NAME: **ROBERT SUTTON**

APPLICANT: NSW DEPARTMENT OF EDUCATION.

APPLICATION NUMBER: SSD-10465

STATEMENT OF NIL SUPPORT: **OBJECTION.**

EXISTING SITE PLAN

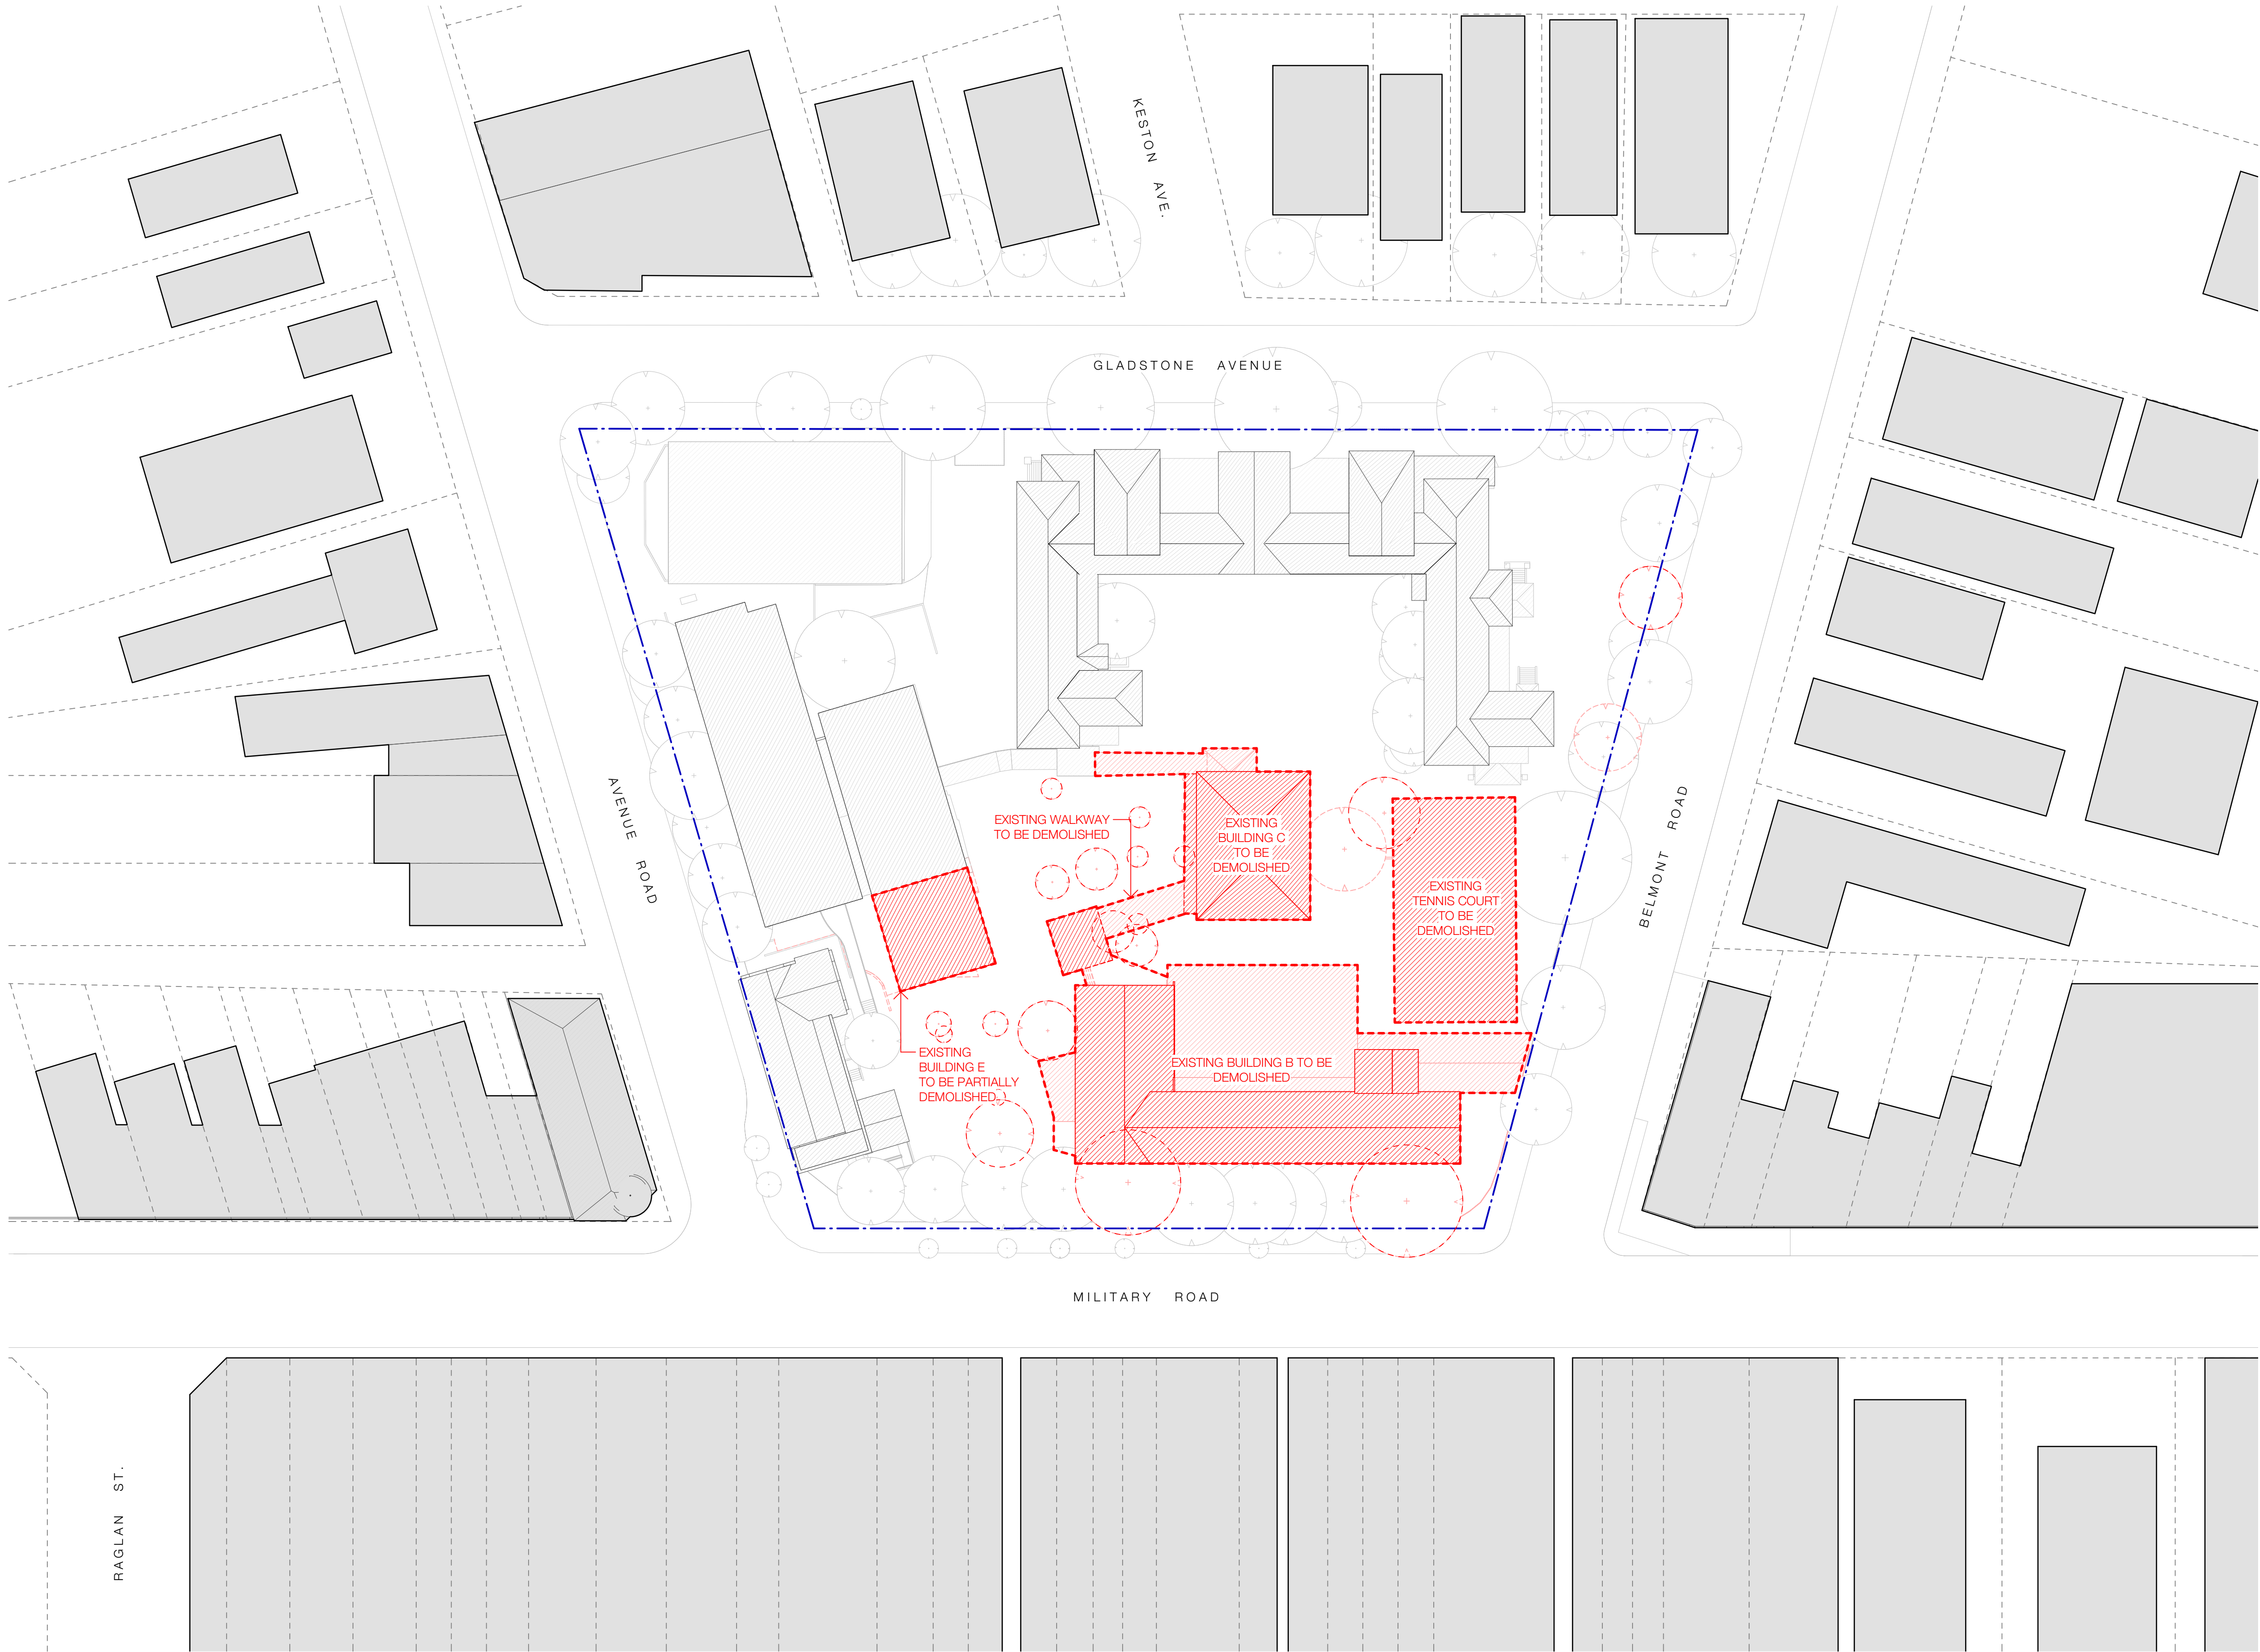
1. WOOD BAGOT SITE PLAN (SSD-1101 Rev2).
We note that plans submitted for public comment are very PRELIMINARY and misleading. This is unacceptable as they are technically wrong and do not reflect the actual site layout. EVIDENCE: The missing presentation of existing structural 30 CAR PARKS on site on the Belmont Road & Gladstone Avenue site North West corner.

Sheet title
WINTER SOLSTICE SHADOW
DIAGRAMS - 9AM-10AM

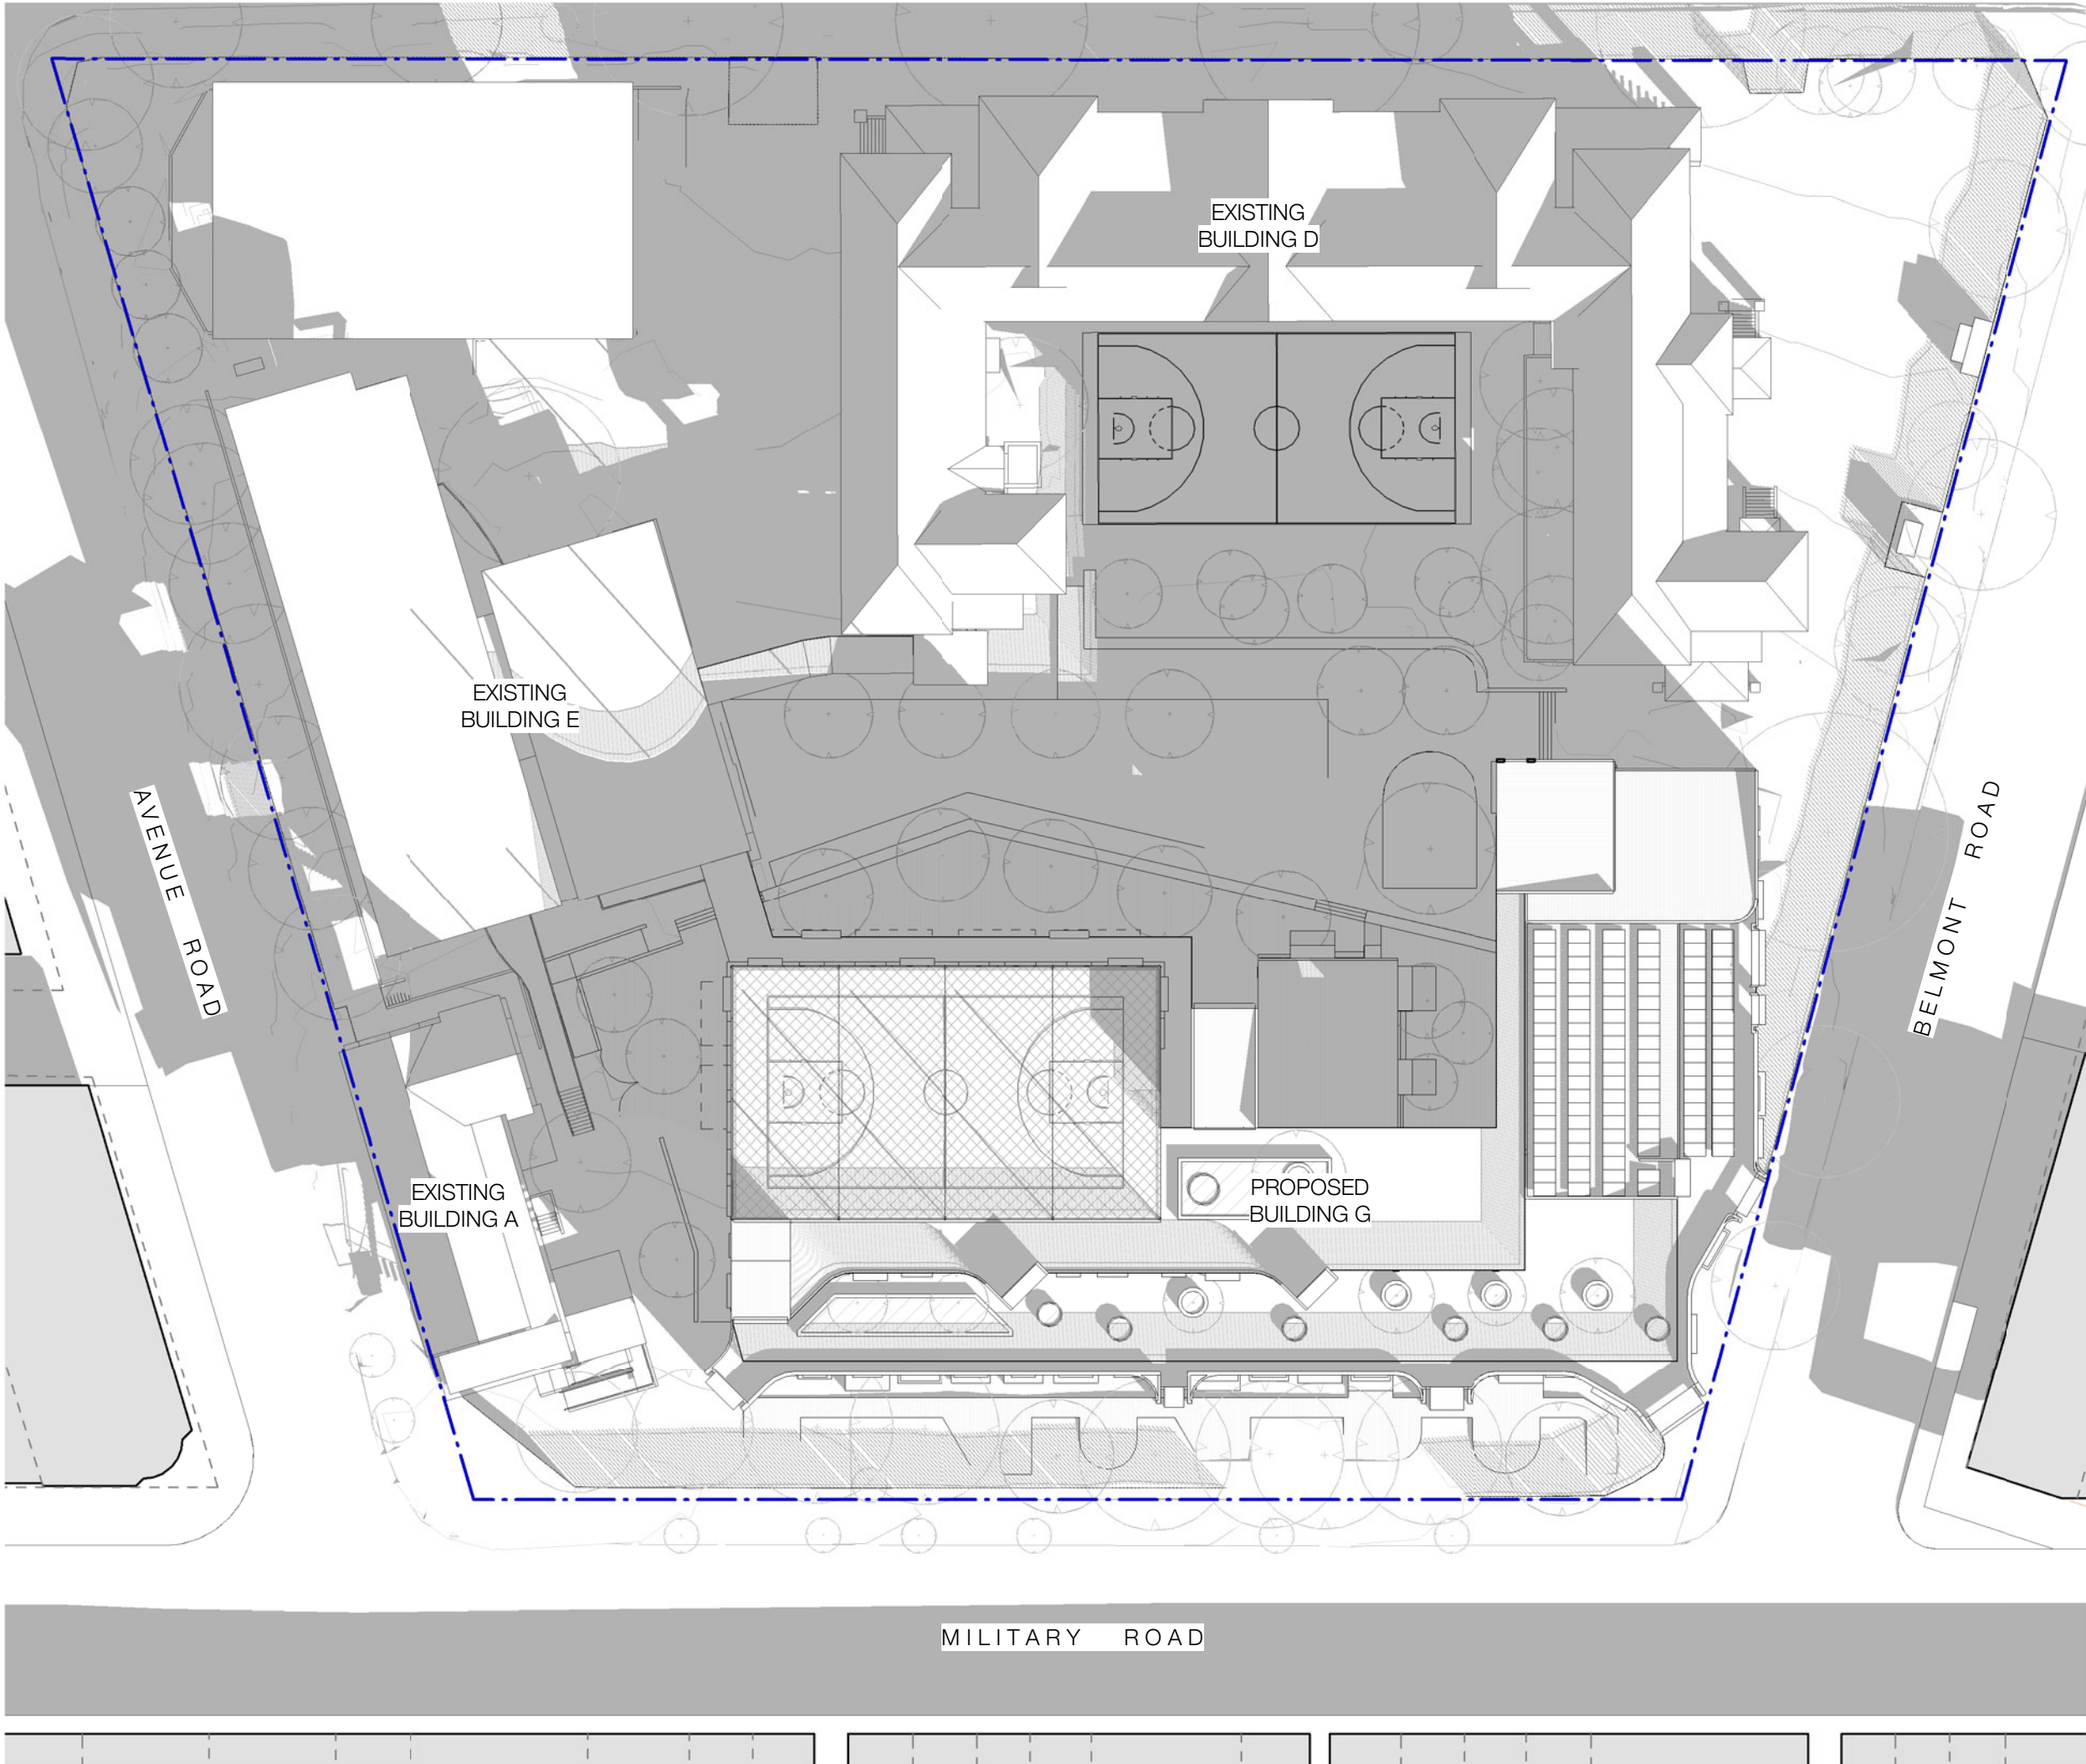
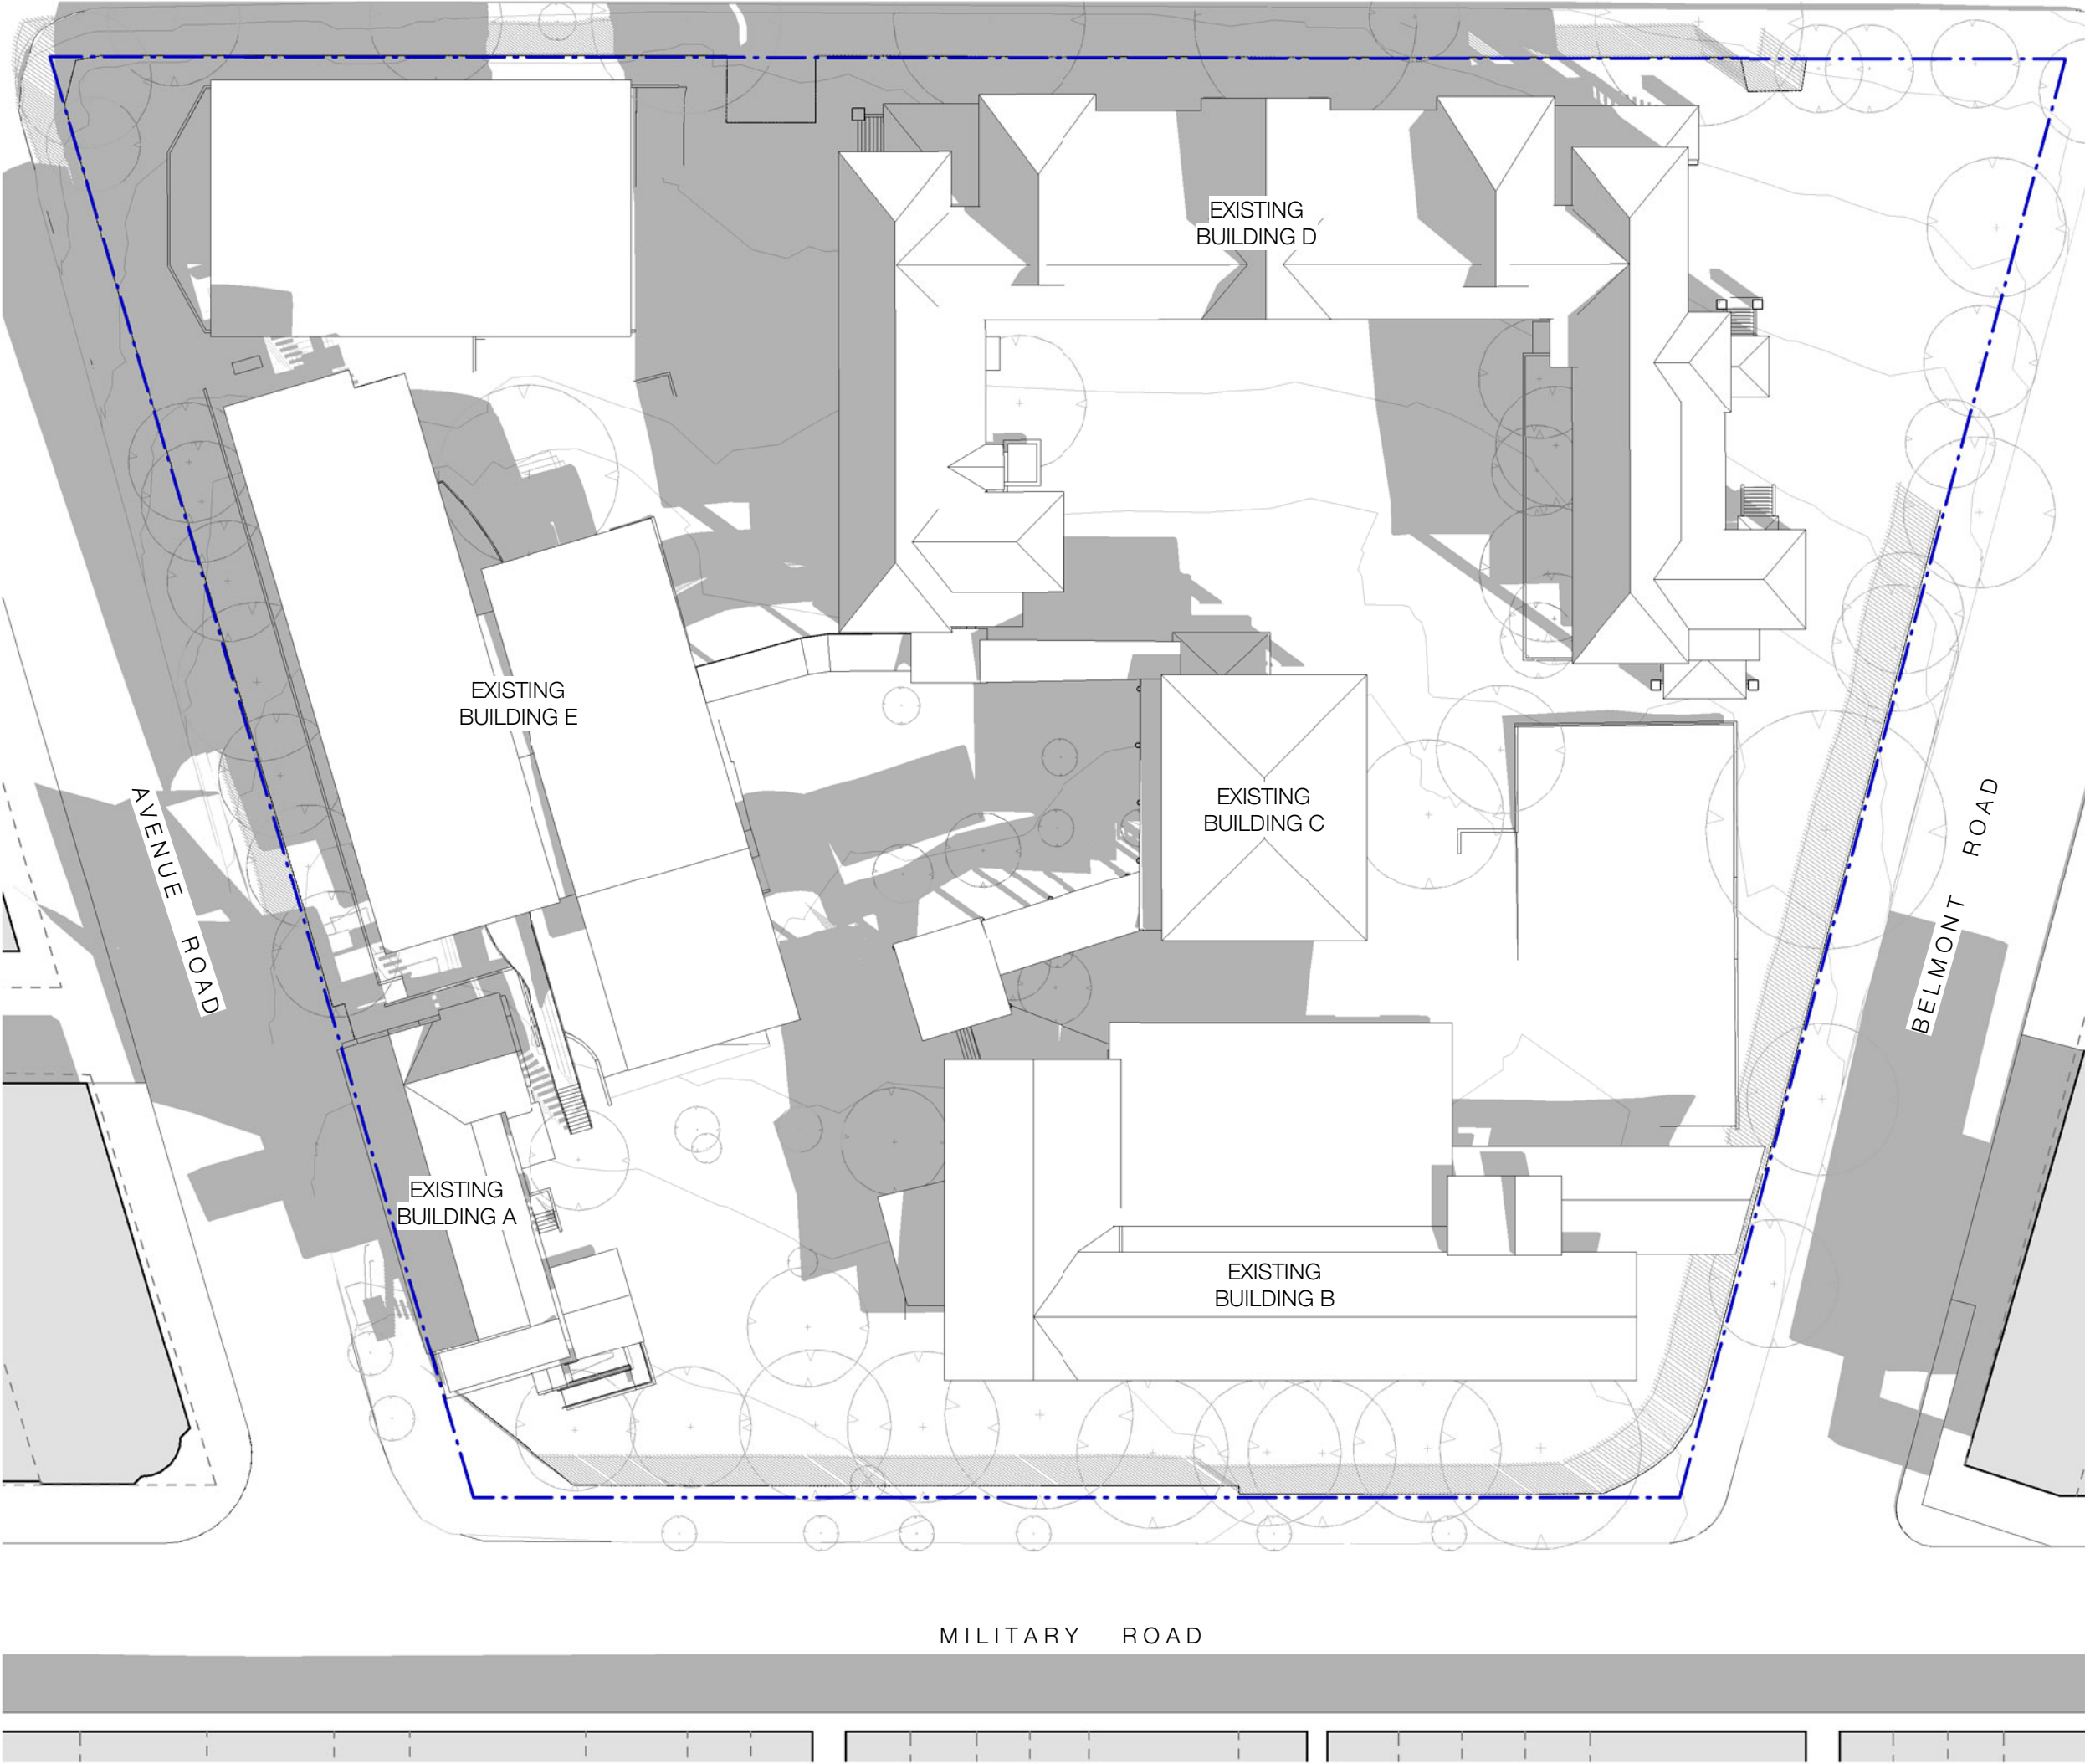
4. WOOD BAGOT SITE PLAN (SSD-1104 Rev2).
We note that plans submitted for public comment are only PRELIMINARY. This is unacceptable as they are technically incomplete and do not reflect the actual site complete shadow diagrams. Evidenced by the missing presentation of FULL SHADOW DIAGRAMS on impacted (Morning) Belmont Road, Keston Avenue & Avenue Road e.g. South West corner 6:00am(Summer) to 7:30am(Winter). Let's be honest – Easterly morning sun shine is critical to our neighbours amenity. (Afternoon) – Military Road retail shopping strip (Winter) 3:00 - 5:00pm. Let's keep the retail street sunny and a great place to shop.
